**KIRKLEES METROPOLITAN COUNCIL
INVESTMENT & REGENERATION SERVICE**

DELEGATED DECISION TO DETERMINE PLANNING APPLICATIONS

Reference No: 2021/62/91035/W

Description: Alterations to existing dwelling to form 4 flats and erection of bike shed (within a Conservation Area)

PROPOSED FRONT ELEVATION

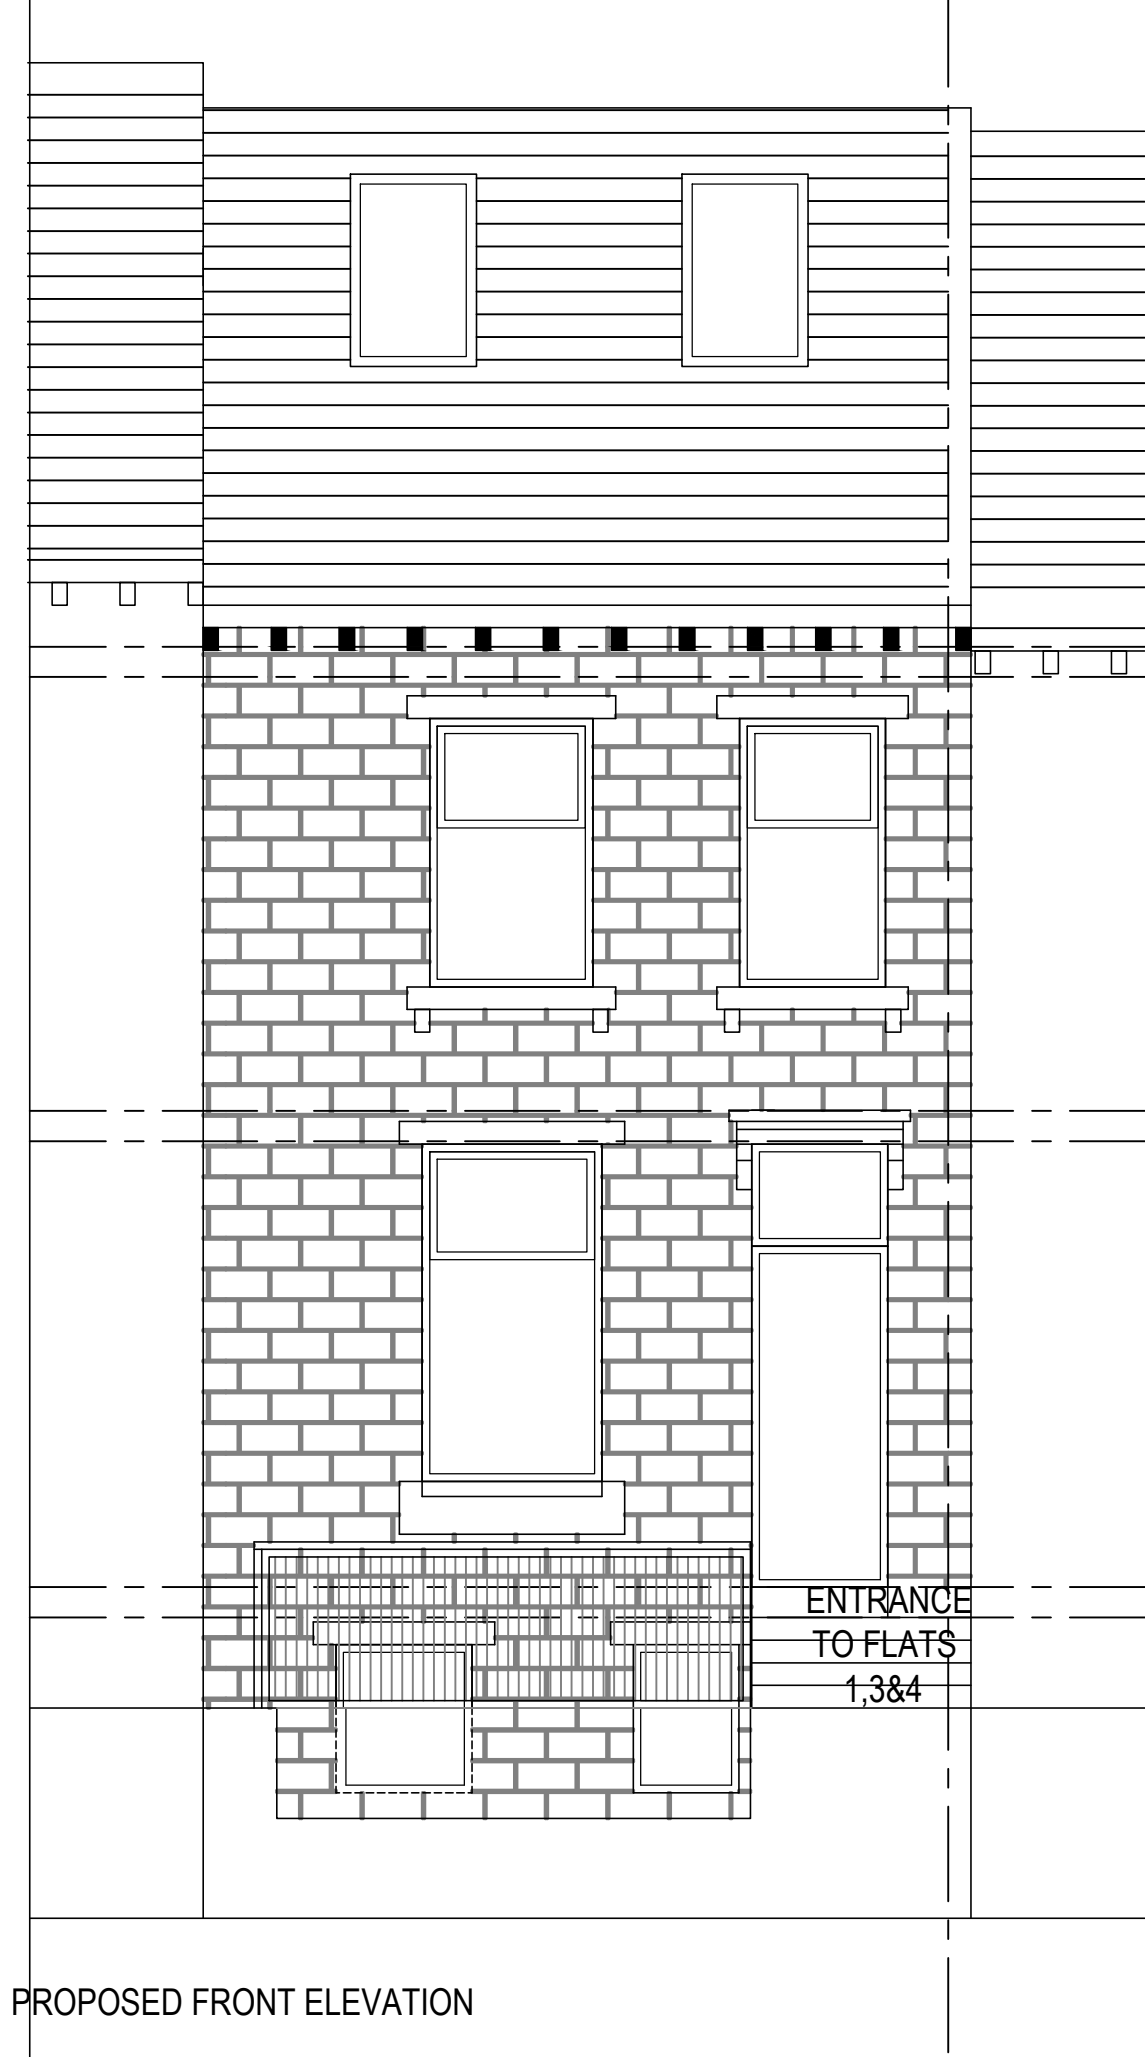
Amendments were sought to remove both the originally proposed front and rear dormer windows and include a lightwell on the front elevation of the property. Additional information was also requested in respect to how the future occupiers would access the proposed bike shed within the rear garden/amenity area.

It has been considered that the impact on visual amenity and the Conservation Area would be limited to the main external alterations of the proposal which includes the formation of a lightwell on the front elevation, erection of a bike shed, and installation of a new entrance door at basement level, alterations to 1 existing door to the rear to provide a window, and an enlarged window at basement level. Each element of the development will be assessed below.

Officer note: Noted. Amended plans have been received which now remove the proposed dormer windows to both the front and rear of the property.

PROPOSED BASEMENT FLOOR PLAN
(FLAT 1)

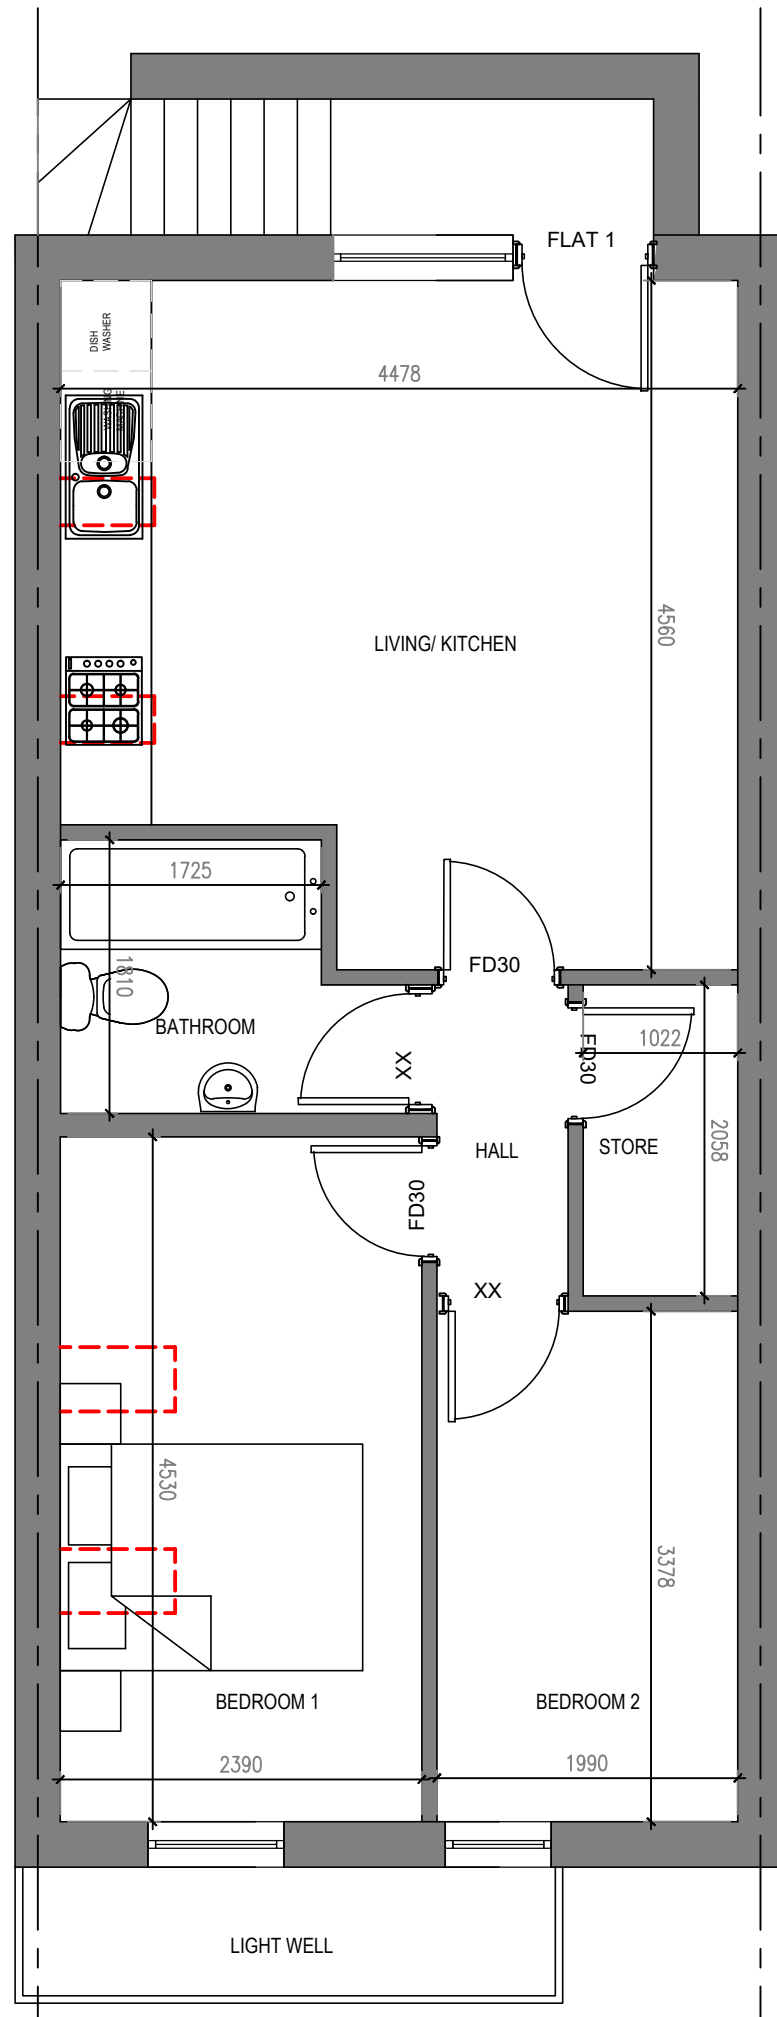
This flat would be accessible from the rear of the dwelling and would be located within the basement. The flat comprises of 2 bedrooms, living/kitchen, bathroom and store. It would have an internal floorspace of approximately 44.88sqm. There would be 1 window to the rear and 2 windows served via a lightwell to the front. All habitable rooms would be served by at least 1 window albeit the quality of the outlook and light gained from these windows will be discussed further into this report.

In regards to Flat 1 the double bedroom has an approximate floor area of 10.8sqm, and a width of 2.4m. The second single bedroom is to have a floorspace of 6.27sqm and width of 1.9m. Both of these bedrooms would fall short of the above standards. Flat 2's double bedroom has an approximate floor area of 10.3sqm and a width of 2.3m. This bedroom therefore also falls short of the standards. Flat 3's double bedroom has an approximate floor area of 12.3sqm and a width of 4.4m. This bedroom would meet the recommended standards. Finally Flat 4 would comprise of one double bedroom measuring approximately 14.96sqm and would have a width of 4.4m. This bedroom would also meet the standards. However, it is noted that as this room is to be located within the attic space it is likely that there is restricted headroom in parts. No section drawings have been provided by the applicant's agent and therefore an assessment of this cannot be undertaken. When considering the likely areas of restricted headroom, it is likely that this flat may not meet the standards recommended. The standards state that a minimum floor to ceiling height is to be 2.3m for at least 75% of the gross internal area.

Flat 1 is located at lower ground floor level and would comprise of a total of 2 windows to the front elevation and 1 window to the rear. These windows are

located partly above but mostly below ground. The provision of habitable space within a basement is far from ideal, with light and outlook being consequently very poor even with the new lightwell proposed to the front. Views from the windows to the front would be at or near the level of the existing front garden and therefore somewhat restricted. Whilst it is acknowledged that natural light taken from the rear window would be a little better given the excavation required to create the stairwell, the outlook would remain substandard with future occupiers looking out to a retaining wall, with no views out into the rear garden area. In addition, it must be noted that the basement windows would be close to Blacker Road itself which is a busy thoroughfare, especially in this location close to its signal controlled junction with Wheathouse and St. John's Road. The potential for noise and disturbance from traffic, including queueing traffic, added to the lack of habitable space, light and outlook would result in a poor standard of amenity for future occupiers.

As such, taking the above assessment into account, it is considered that the overall living environment for future occupants of flat 1 would be gloomy and oppressive, with limited access to natural light and a poor outlook together with likely disturbance from traffic on Blacker Road. As such the proposals are not deemed to be acceptable in terms of residential amenity and would not comply with Local Plan Policies LP24 of the Kirklees Local Plan, Chapter 12 of the National Planning Policy Framework and the Council's adopted SPD's.

It is noted that should the proposed double bedrooms be amended to single bedrooms, the proposals, in this respect alone, may be appropriate.

PROPOSED GROUND FLOOR PLAN
(FLAT 2)

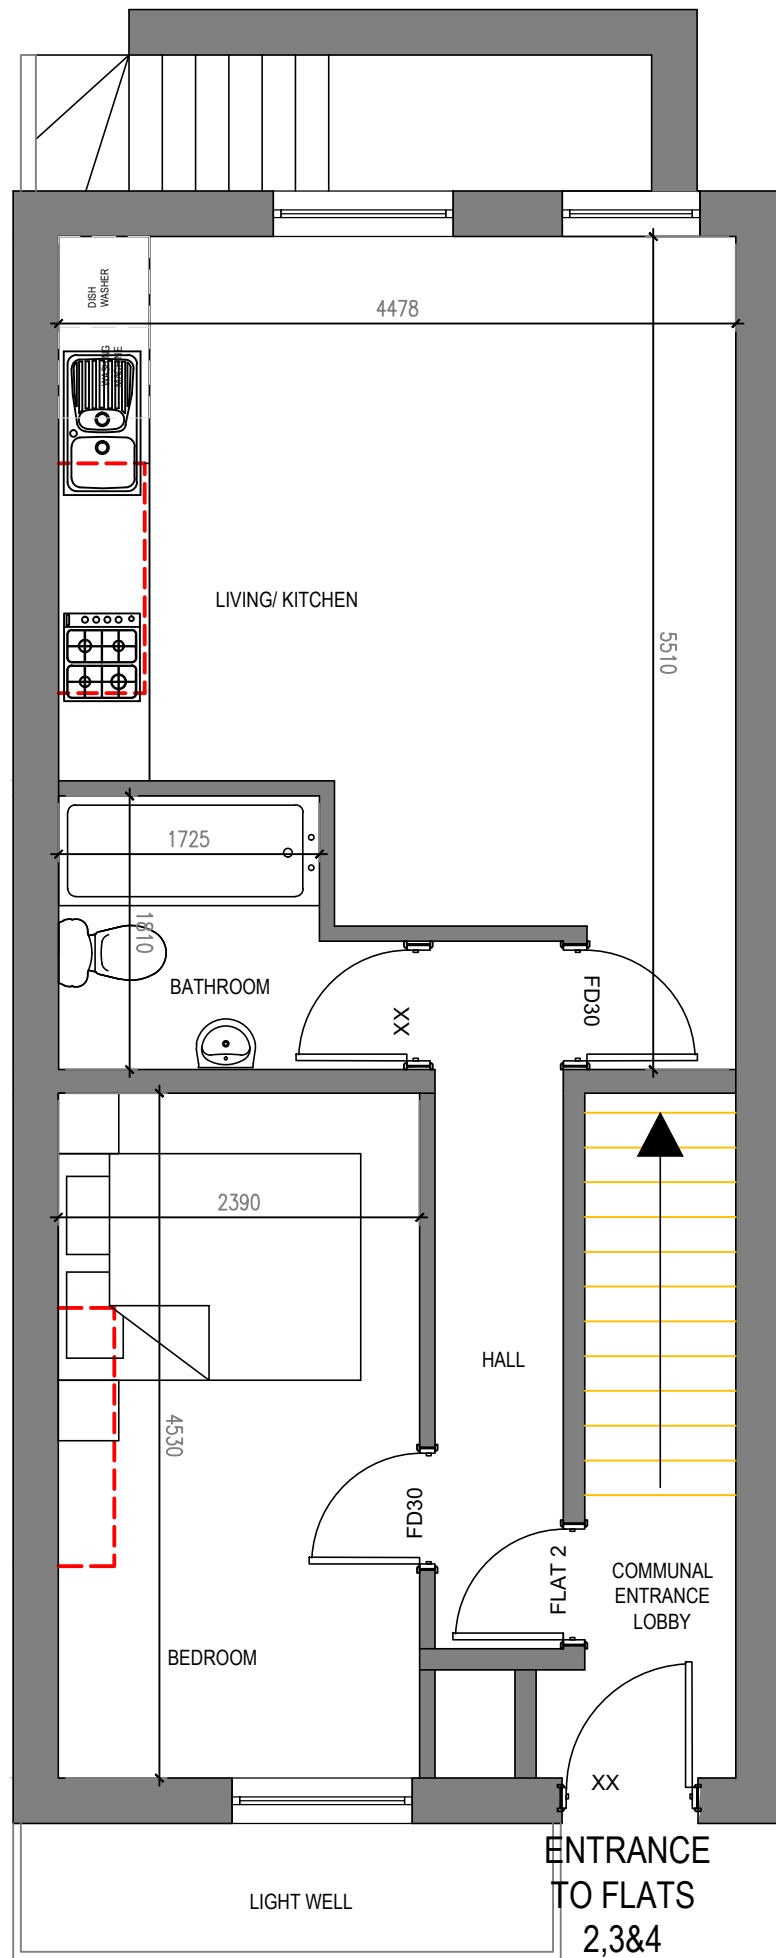
This flat would be accessible from the front of the dwelling and would be located on the ground floor of the property. This flat comprises of a living/kitchen, double bedroom and bathroom. It would have an internal floorspace of approximately 44.88sqm. There would be 1 window to the front and 2 to the rear. All habitable rooms would be served by at least 1 window.

PROPOSED 1ST FLOOR PLAN
(FLAT 3)

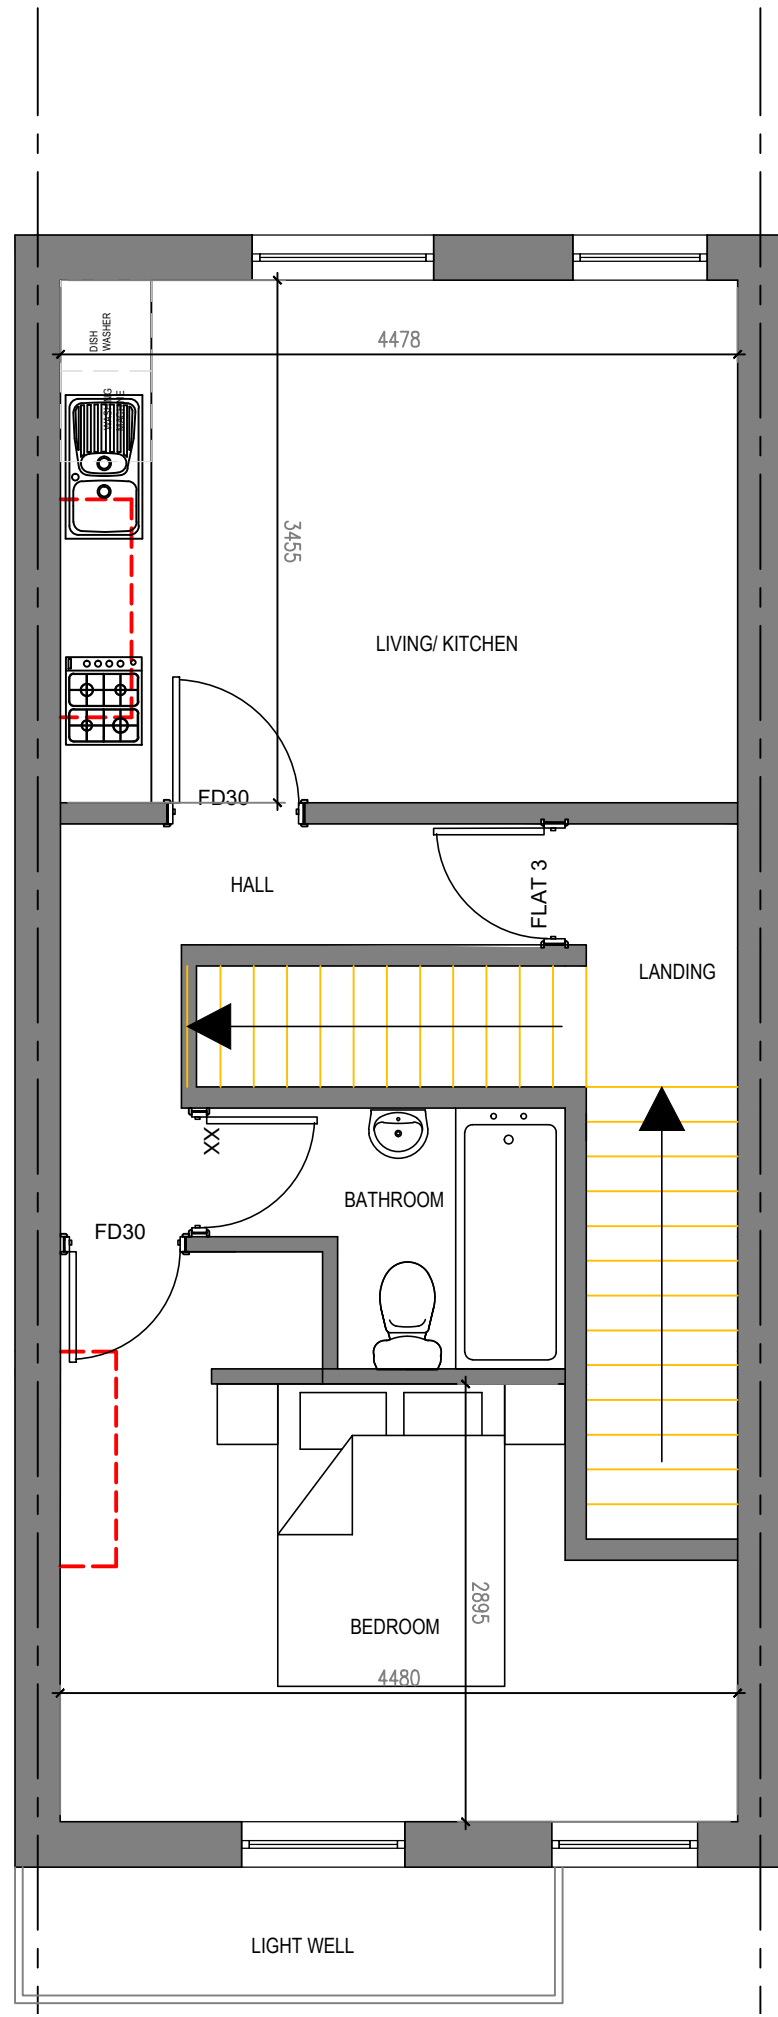
This flat would be accessible from the front of the dwelling and would be located on the 1st floor. This flat comprises of a living/kitchen, double bedroom and bathroom. It would have an internal floorspace of approximately 44.88sqm. There would be 2 windows within the front and 2 in the rear. All habitable rooms would be served by at least 2 windows.

PROPOSED 2ND FLOOR PLAN
(FLAT 4)

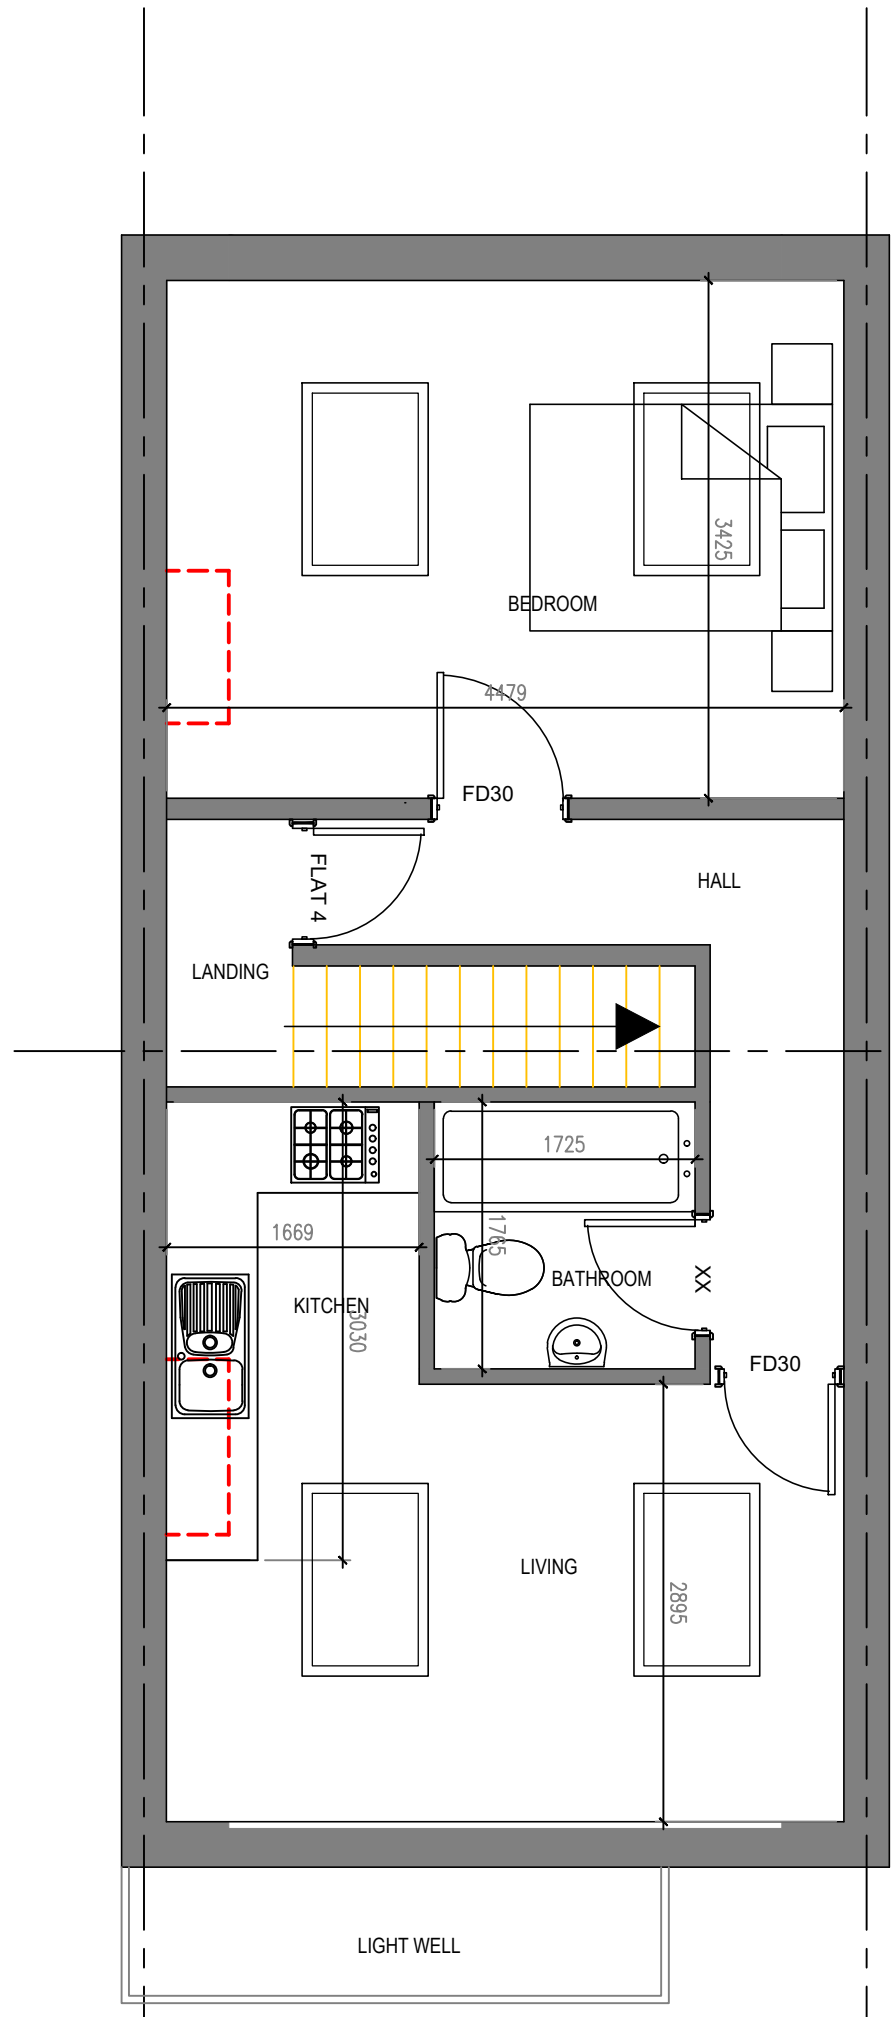
This flat would be accessible from the front of the dwelling and would be located on the 2nd floor (attic). This flat comprises of a living/kitchen, bathroom and double bedroom. It would have an internal floorspace of approximately 44.88sqm. There would be 2 rooflights in the front and 2 rooflights in the back. All habitable rooms would be served by at least 2 windows; however, the quality of outlook will be discussed further into this report.

All of the flats measure approximately 44.88sqm (however this does include the stairways and therefore would be somewhat smaller and furthermore there is no detail of where the head height in the attic apartment would exceed 1.5m in height so the useable floorspace of this flat is lower than the gross floorspace specified). Given the above recommendations it is considered that all 4 units would fall short of this part of the national standards which, in terms of general amenity considerations would not provide a good living standard for future occupiers.
